**RE: SSD 7462 – Minto Recycling Pty Ltd (Bingo Industries)  
No. 13 Pembury Road, Minto**

I refer to the Department's correspondence regarding the proposal to increase the permitted tonnage of waste per annum permitted to be handled at the subject site from its current 30,000 tonnes.

This response has been prepared following receipt of amended information from the proponent, which was prepared in response to submissions raised during the application's public exhibition.

13 PEMBURY ROAD,
MINTO
LOT 1 DP 1013852

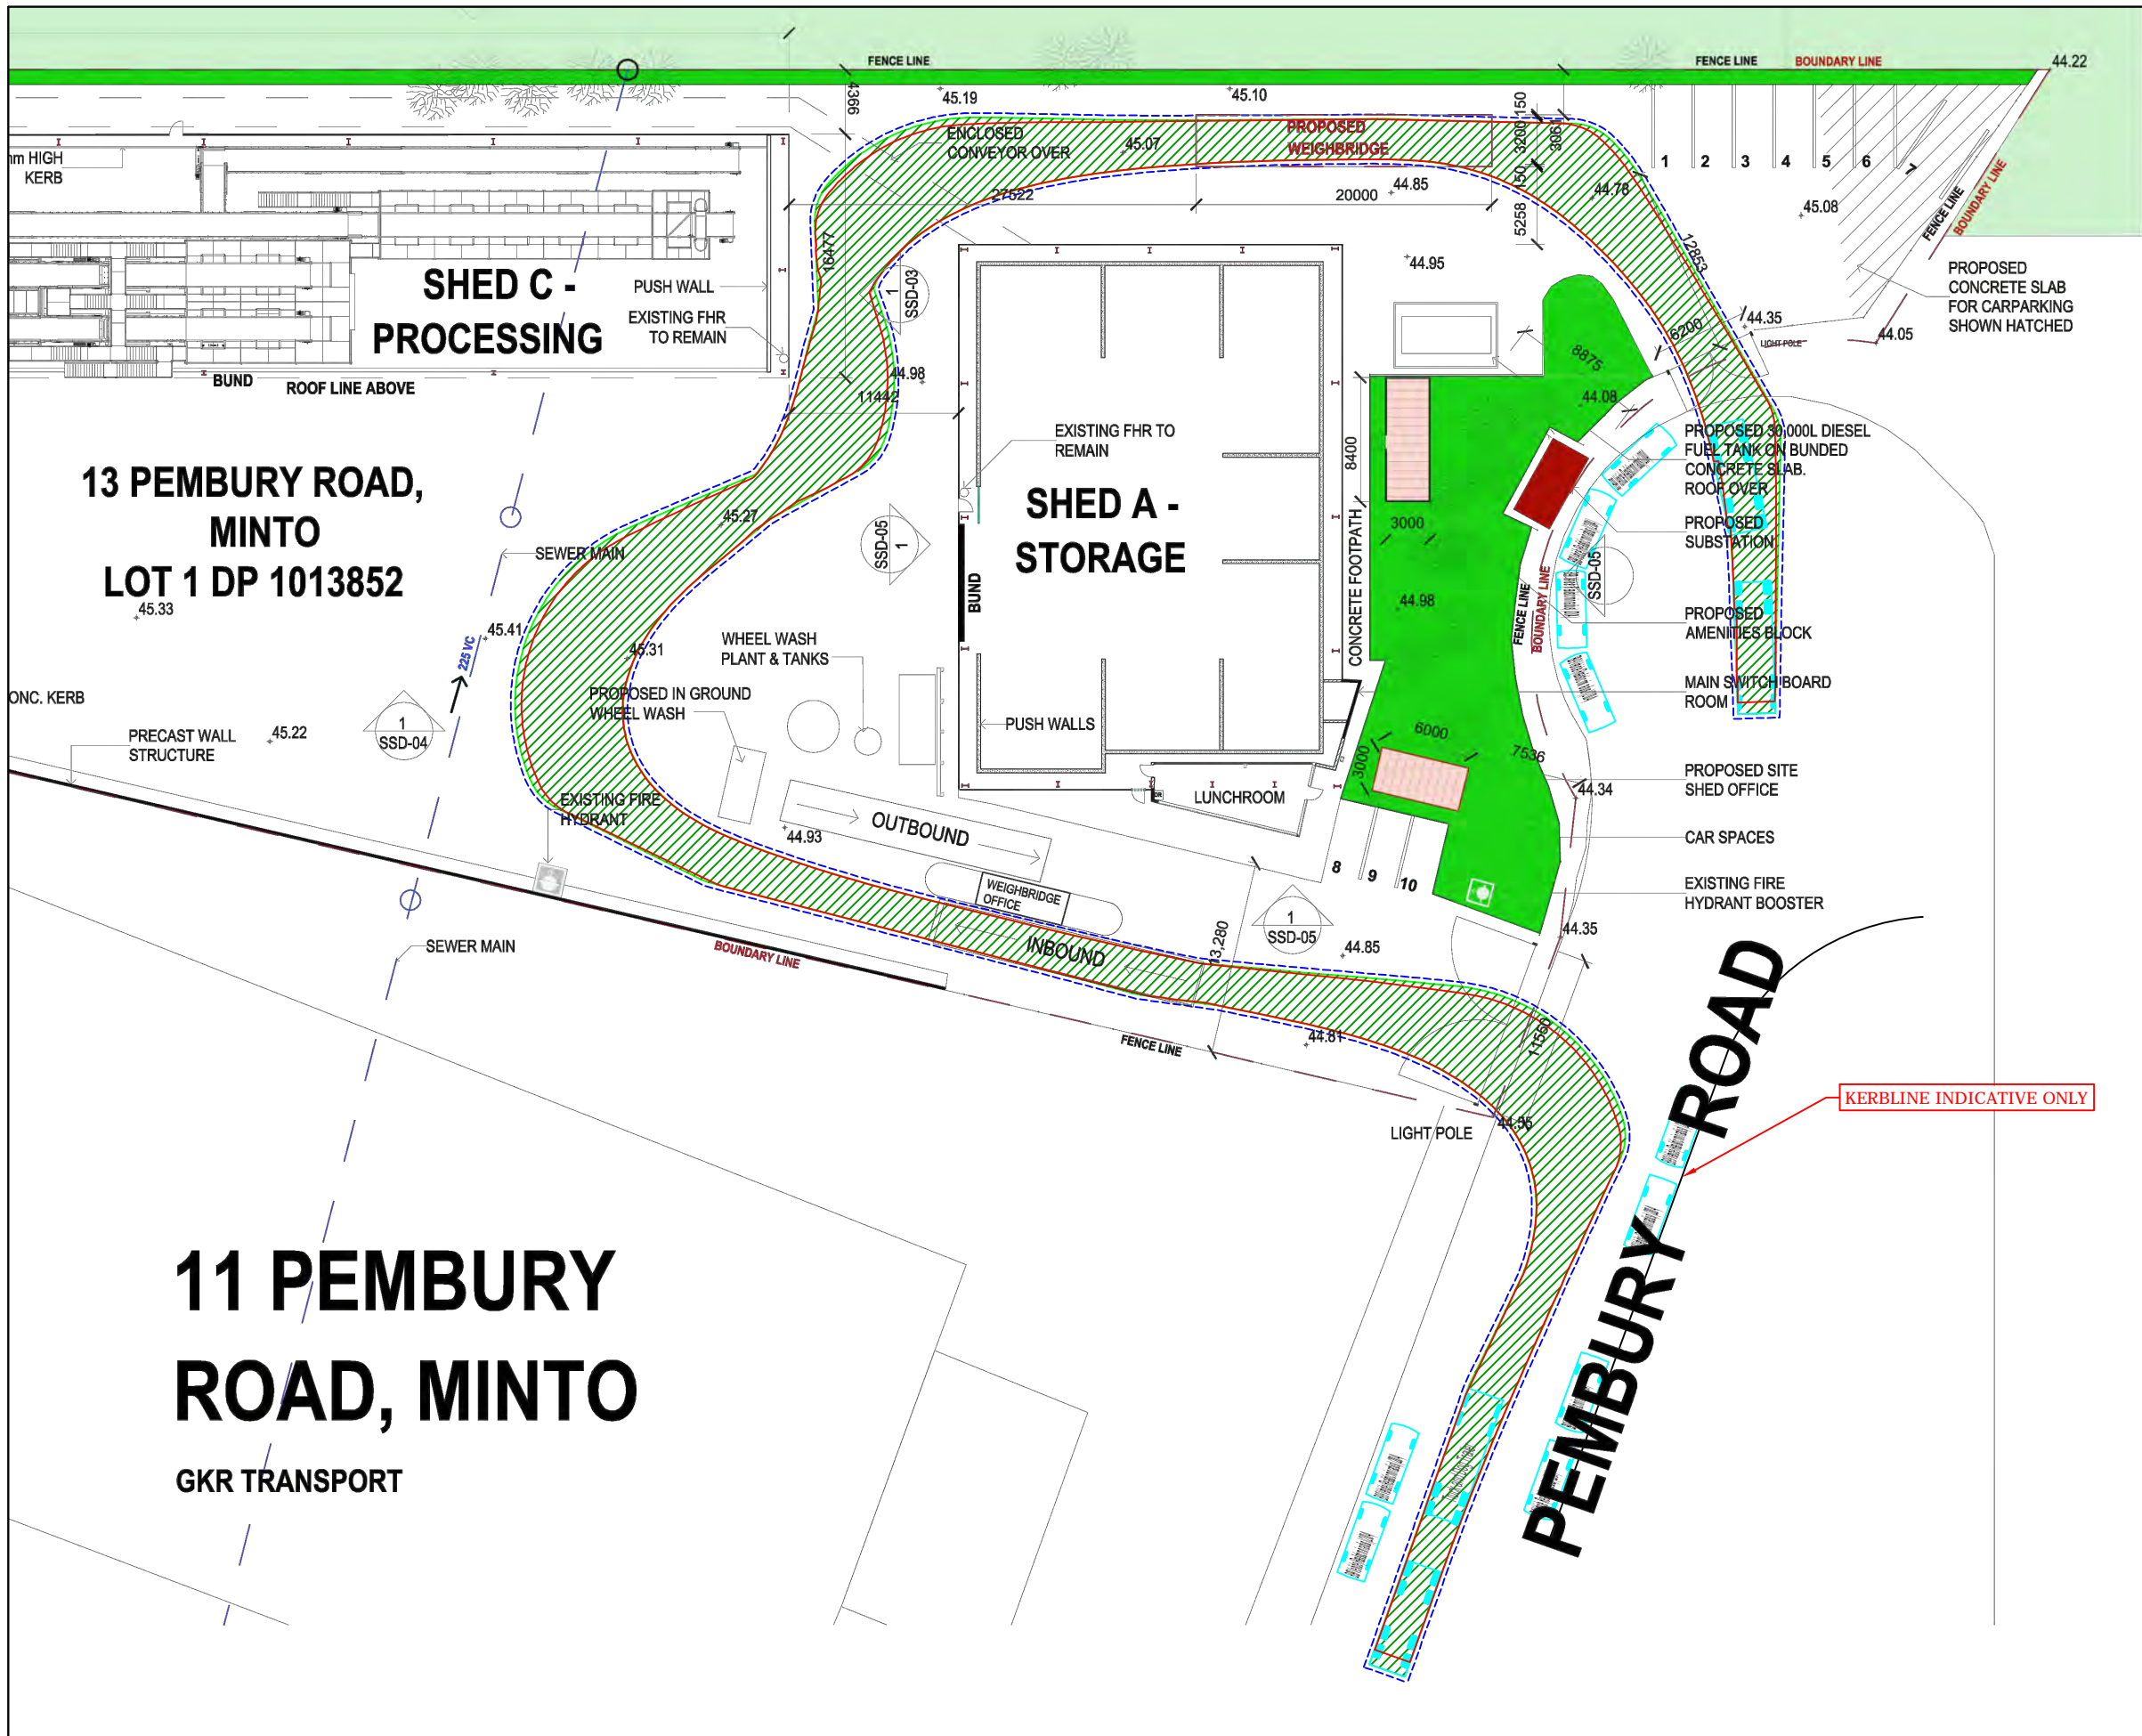
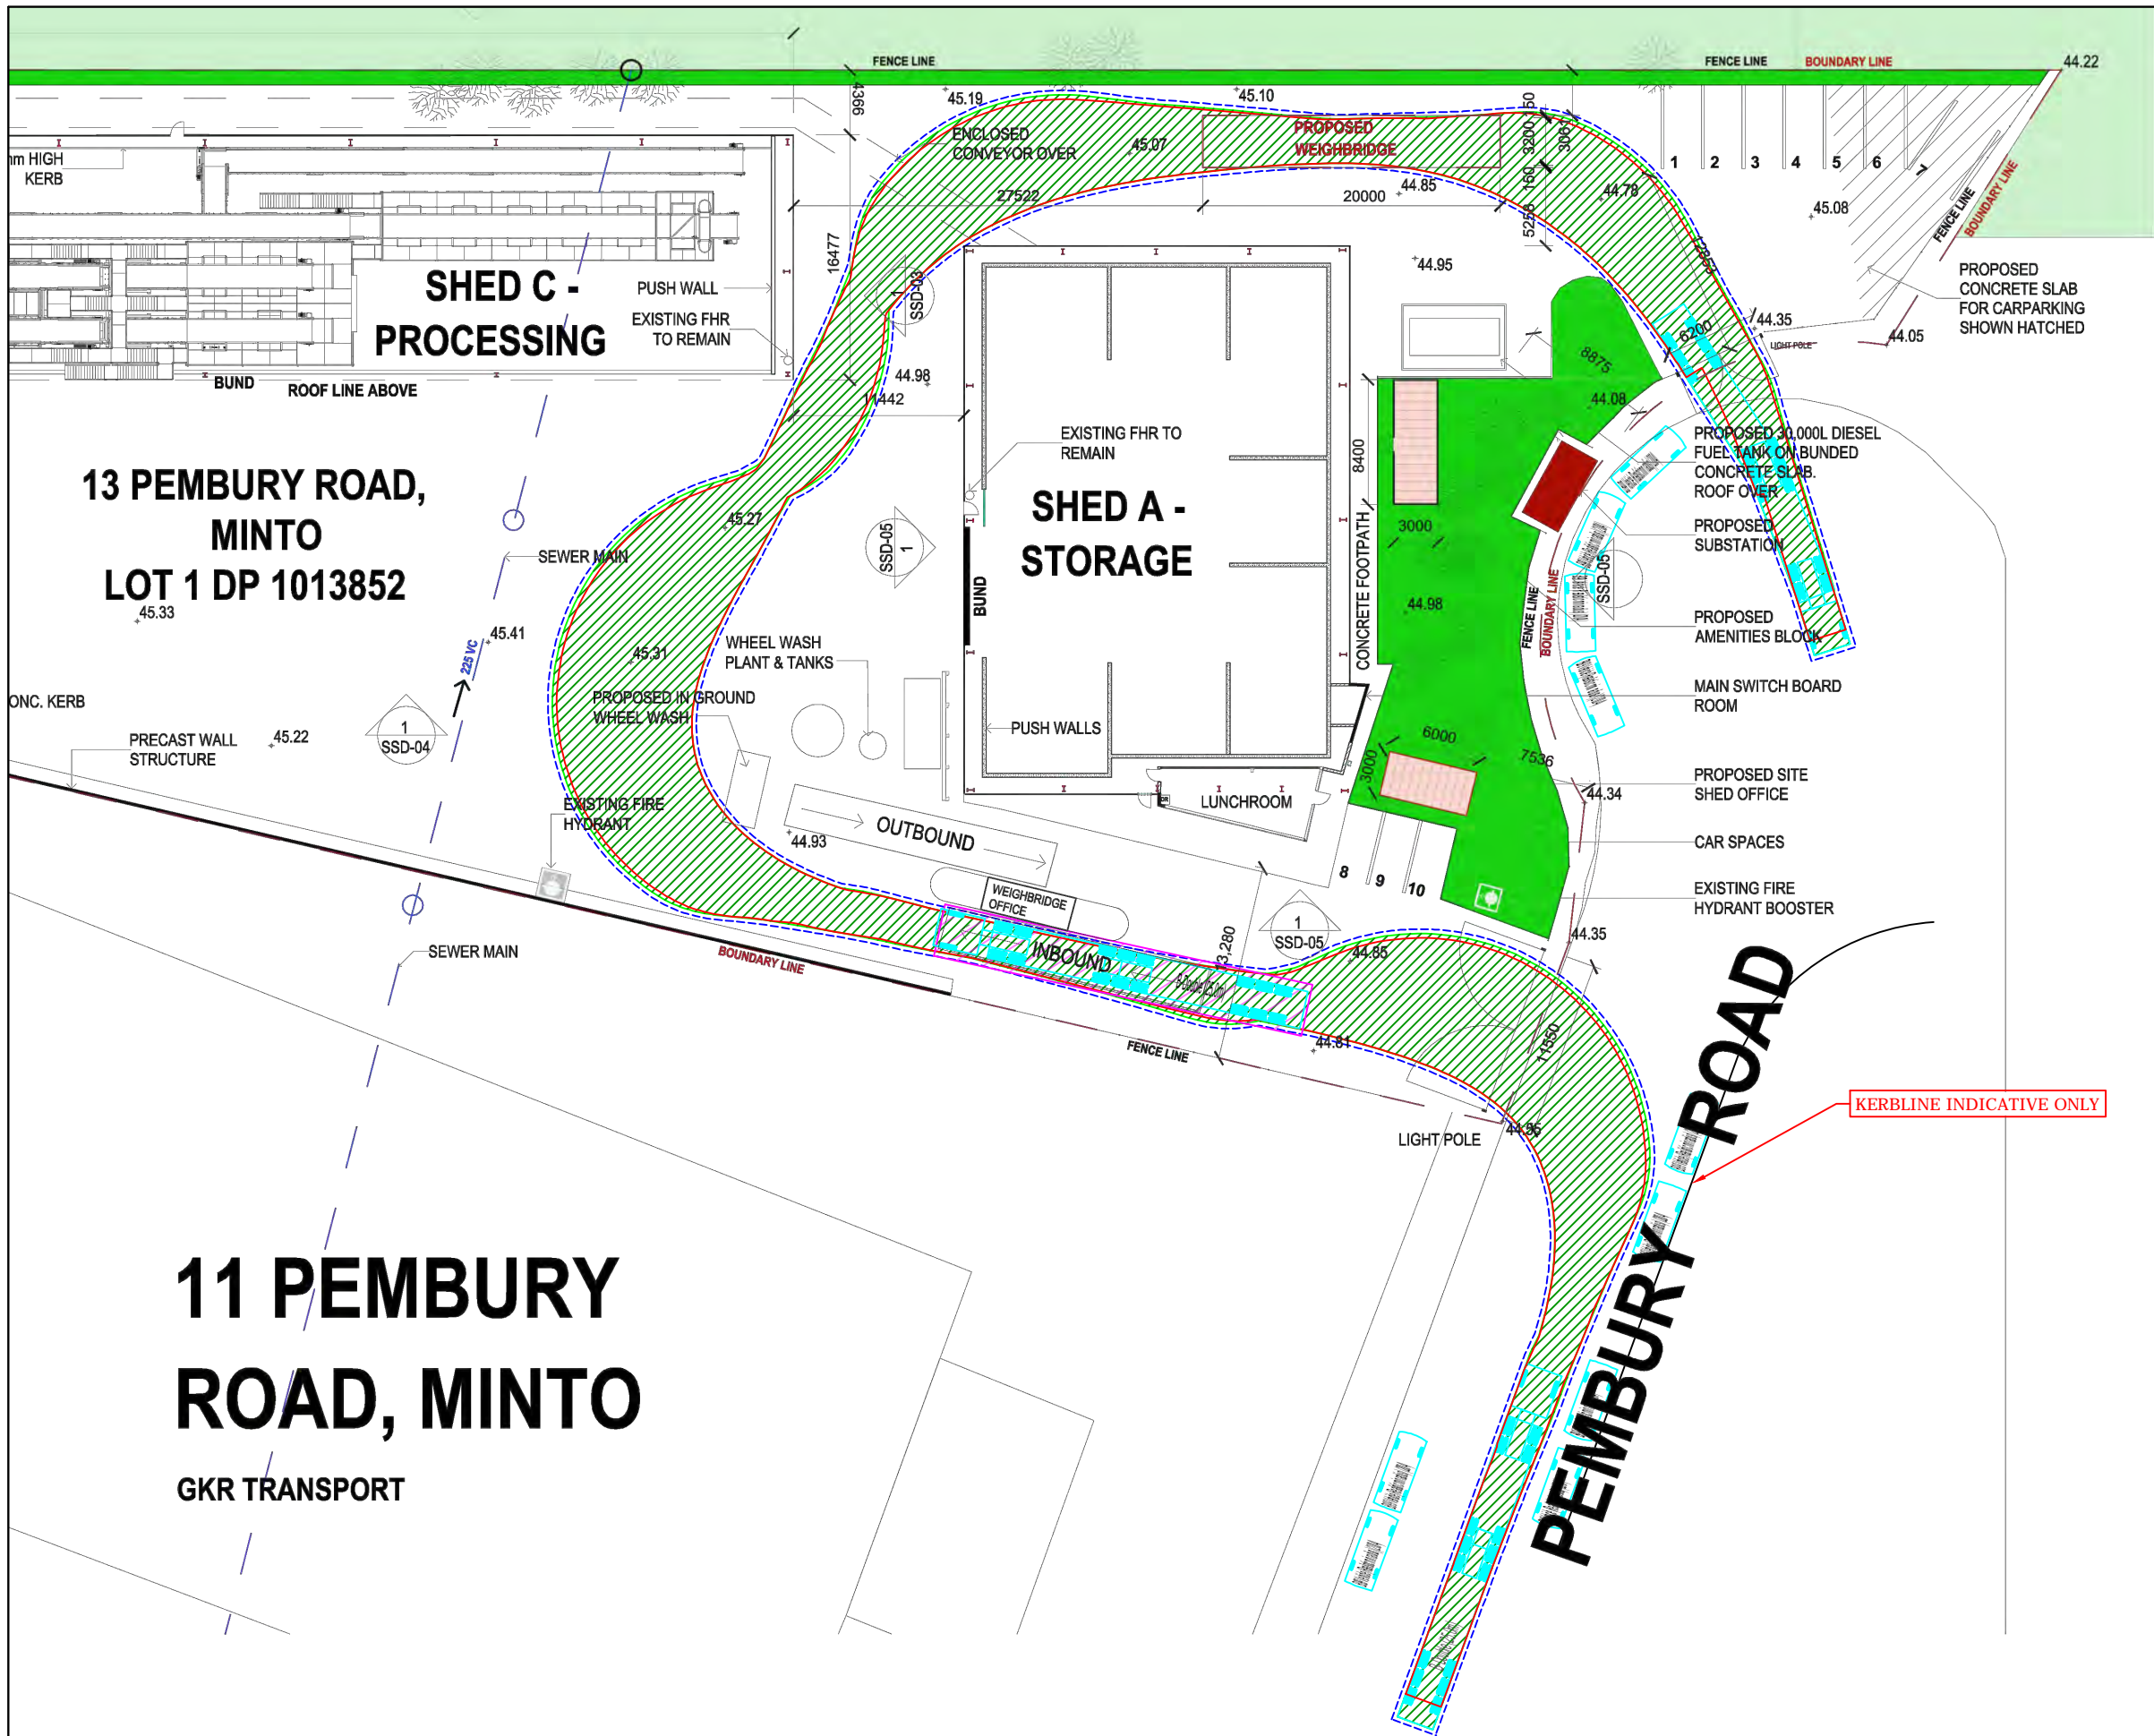
- The turning manoeuvres shown on submitted plans do not appear to be practical in some instances – with wheels crossing over weighbridge edges and the like, which is likely to damage the weighbridge and not be a permitted practice on site. The weighbridges are not generally flush with the surrounding pavement surface. Rather, they are likely to have a raised kerb or other raised element to ensure the vehicle is located appropriately.

- The stacking proposed within the building is not considered to be appropriate in terms of manoeuvring for articulated vehicles – there is no turning path shown that illustrates how an articulated vehicle would access the stack nearest the wall should the vehicle use entry weighbridge number 2. Manoeuvring within the building as proposed is reliant on articulated vehicles being in that particular stack.

- According to submitted turning paths, not all wheels of some articulated vehicles are located on the weighbridge after entering the site. Again, this is important as the weighbridges are not flush with the pavement surface. If vehicles cannot access the weighbridge in either a timely manner and importantly, an accurate manner, this raises issues with the monitoring of the site's performance in terms of its EPA licence restrictions and also the timeliness of the queuing/unloading criteria relied upon in the traffic assessment.

- No reverse to tip manoeuvre turning path is provided for b-double vehicles within the building. Are b-doubles broken down on site in order to perform their tipping manoeuvre? If not, how is the a-trailer emptied? Breaking down of the combinations would add time and influence queuing.
